CITY OF PORTLAND, MAINE
DEVELOPMENT REVIEW APPLICATION
PLANNING DEPARTMENT PROCESSING FORM
DRC Copy

2004-0080
Application I. D. Number

single family dwelling
Project Name/Description

RE: 219 Brackett Avenue, Peaks Island
(ID # 2004-0080, CBL #088M006)

PLOT PLAN  
 (revised)

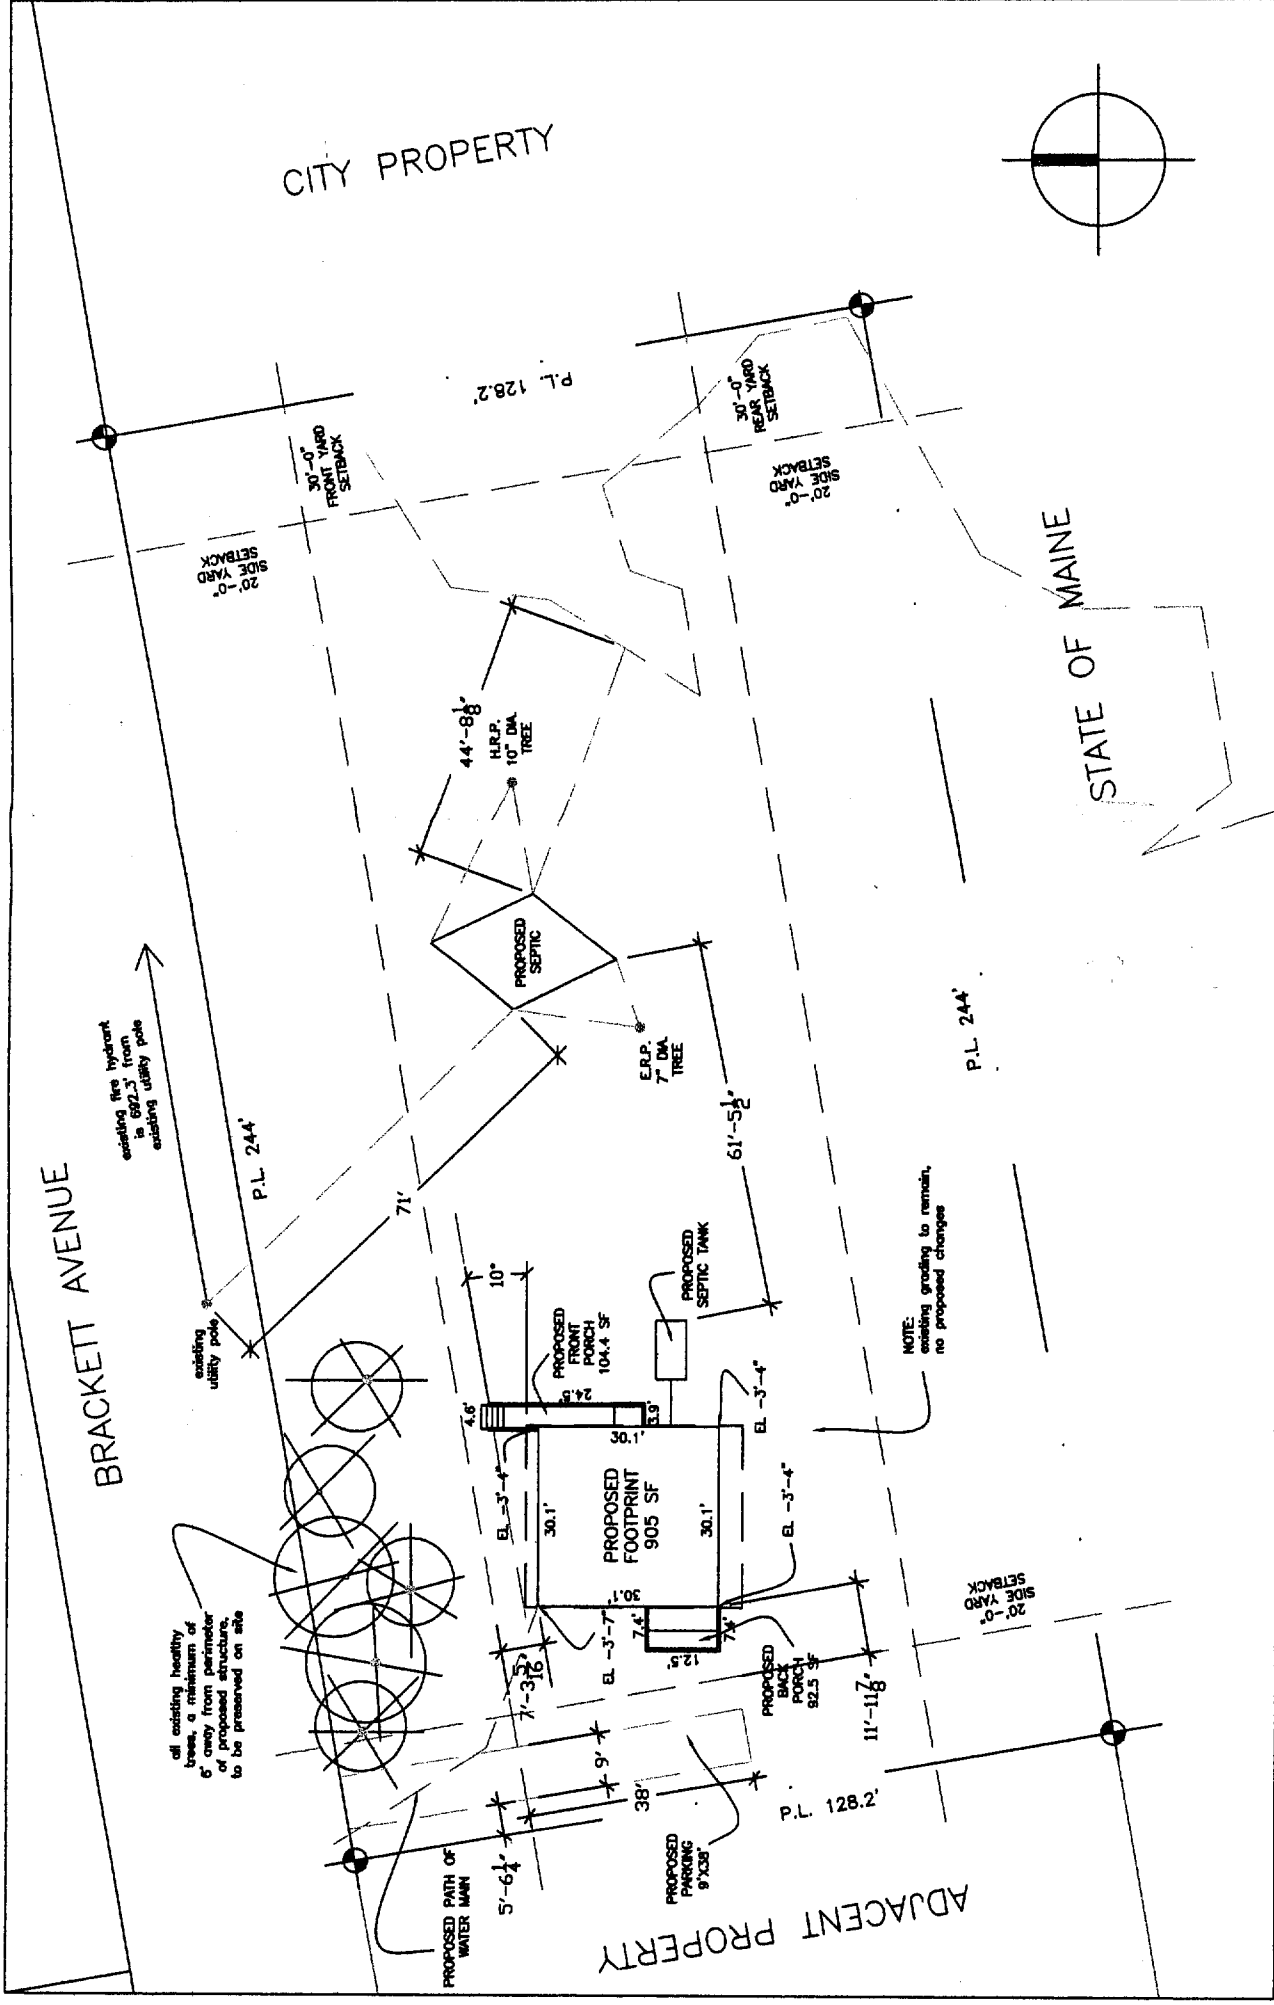
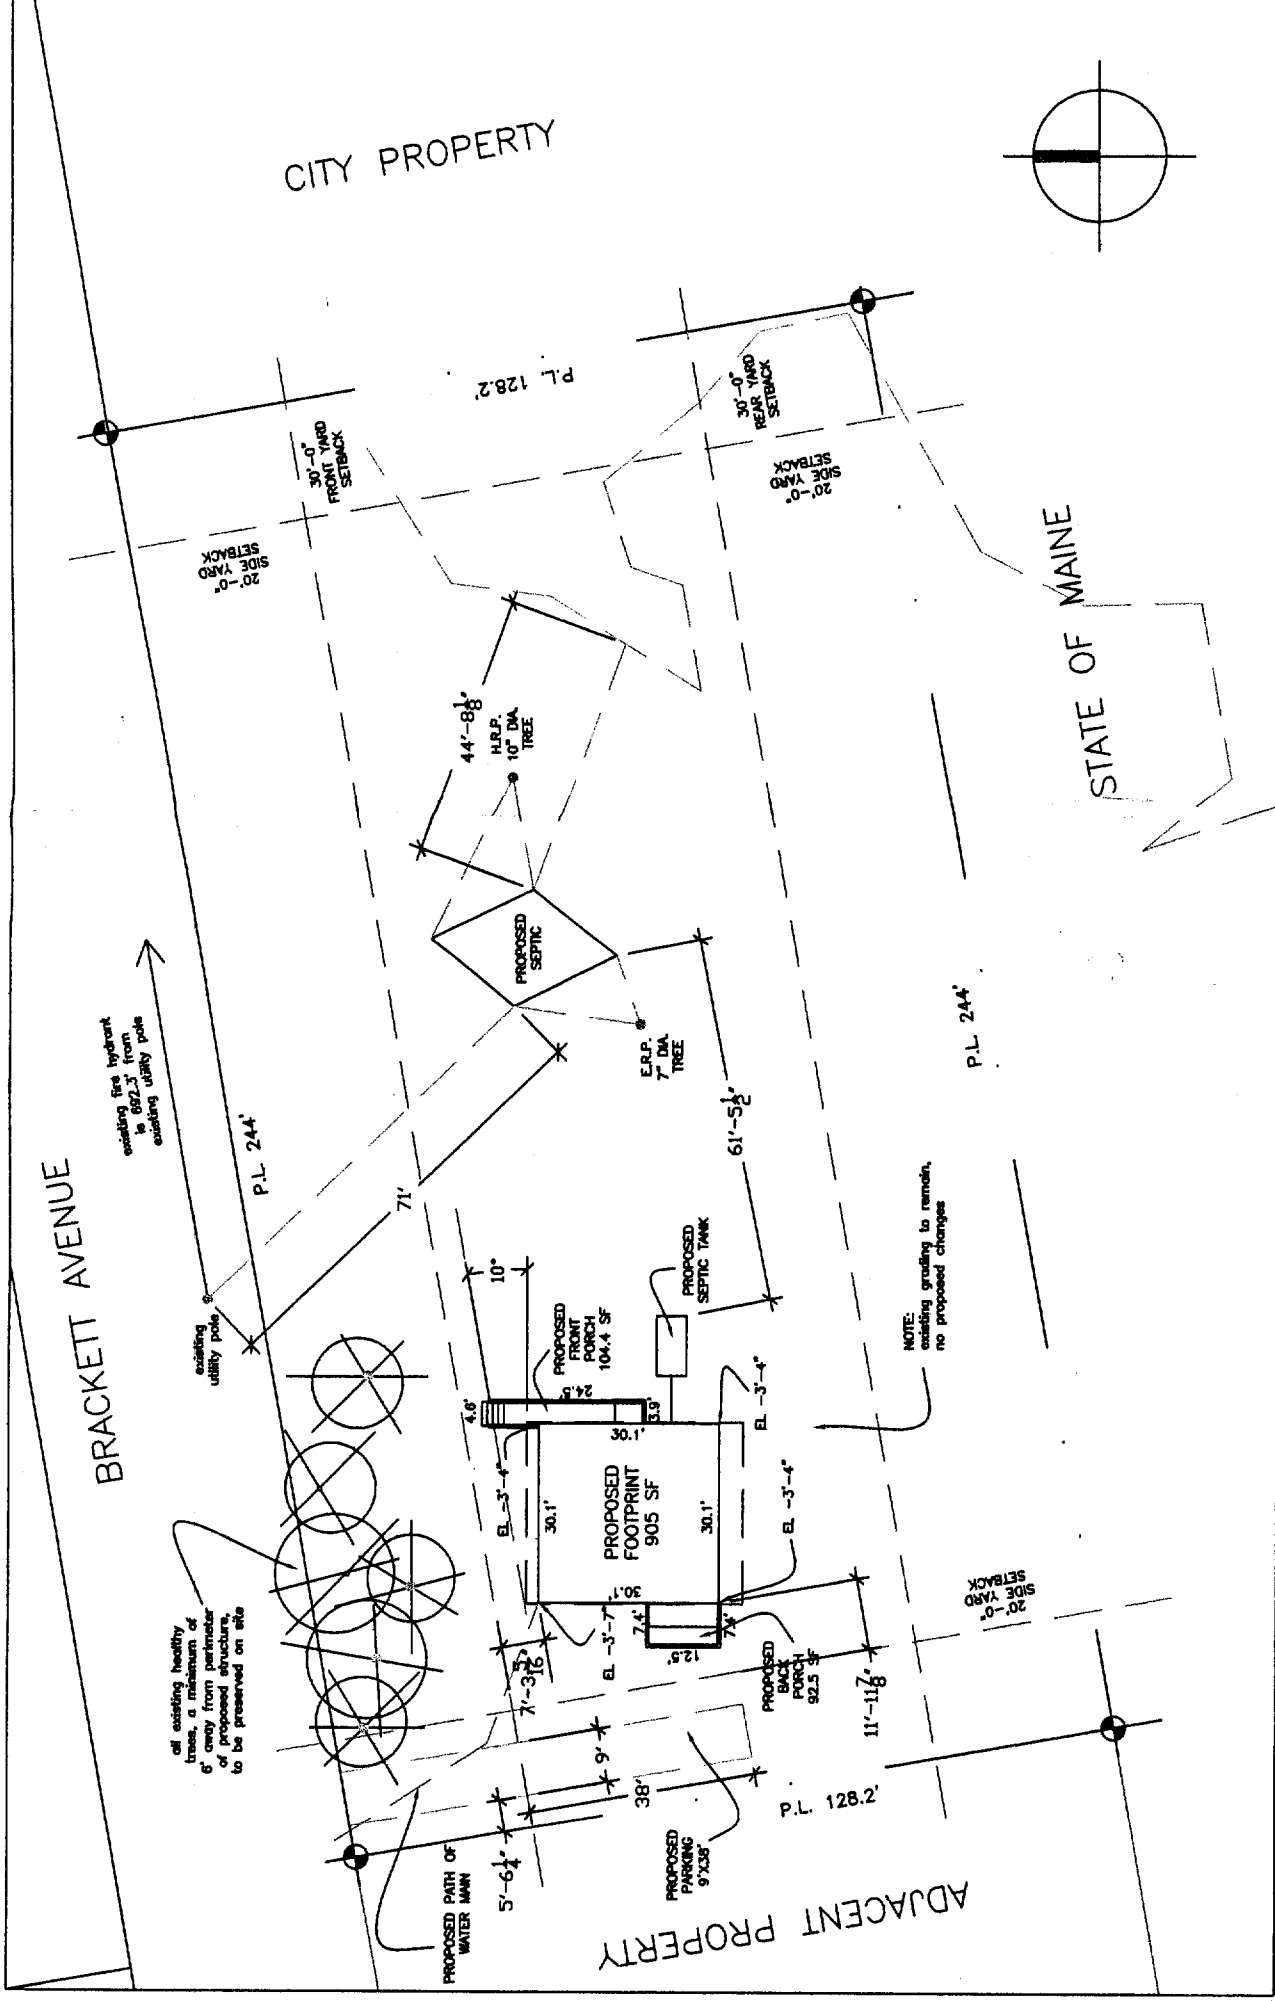
Please find attached corrections made to the permit submission for a new single-family house to be located at 219 Brackett Avenue, Peaks Island. The following corrections have been made to the plot plan per your request:

1. Wetlands have been flagged by Sweets Associates, who are Maine State certified geologists. These flags were then located on the survey prepared by SGC Engineering, LLC.
2. As a result of finding wetlands on the property, I am also submitting a redesign to the septic system, prepared by Sweets Associates. This proposal follows regulations set forth by the Maine Subsurface Waste Water Disposal Rules, 144A CMR 241.

1. Please add any/all proposed changes in grading. Also, add the sill or finish floor elevation.
2. Please add 2 proposed street trees along the ^{*Brackett*} Island Avenue frontage of the lot, as required by ordinance for single-family development. Saving existing healthy trees (as substitutes) is allowed by adding a tree preservation note to the plan.
3. Please show proposed utilities such as water, sewer and storm drain.
4. Please note the distance of the nearest fire hydrant on the site plan.
5. Please indicate any drainage courses, streams, and wetlands. Also, the City's zoning map indicates that there may be a resource protection zone in the vicinity of your lot. Please show this on your site plan.

- ✓ 1. I have added a note which states "existing grade to remain, no proposed changes". As well, I have included copies of the south, west, north and east elevations which show the finish floor elevation.

- ✓ 2. I have added trees and a note which states "all existing healthy trees, a minimum of 6' from the perimeter of the proposed structure, to be preserved on site".

- ✓ 3. I have added a dashed line which shows the path of the proposed water main, as well, I have drawn the proposed septic tank and 20 Eljen In-Drain Type B.

- ✓ 4. I have added the distance and direction of the nearest fire hydrant.
- ✓ 5. I have reviewed the City of Portland Resource Protection and Shoreland Overlay Zones and Floodplains Map. The only Resource Protection Zone I find on Peak's Island is in the location of the "ball field" which is approximately ½ mile away from the proposed site. Therefore, I did not note it on the plot plan. As well, there are no drainage courses, streams or wetlands on the property.
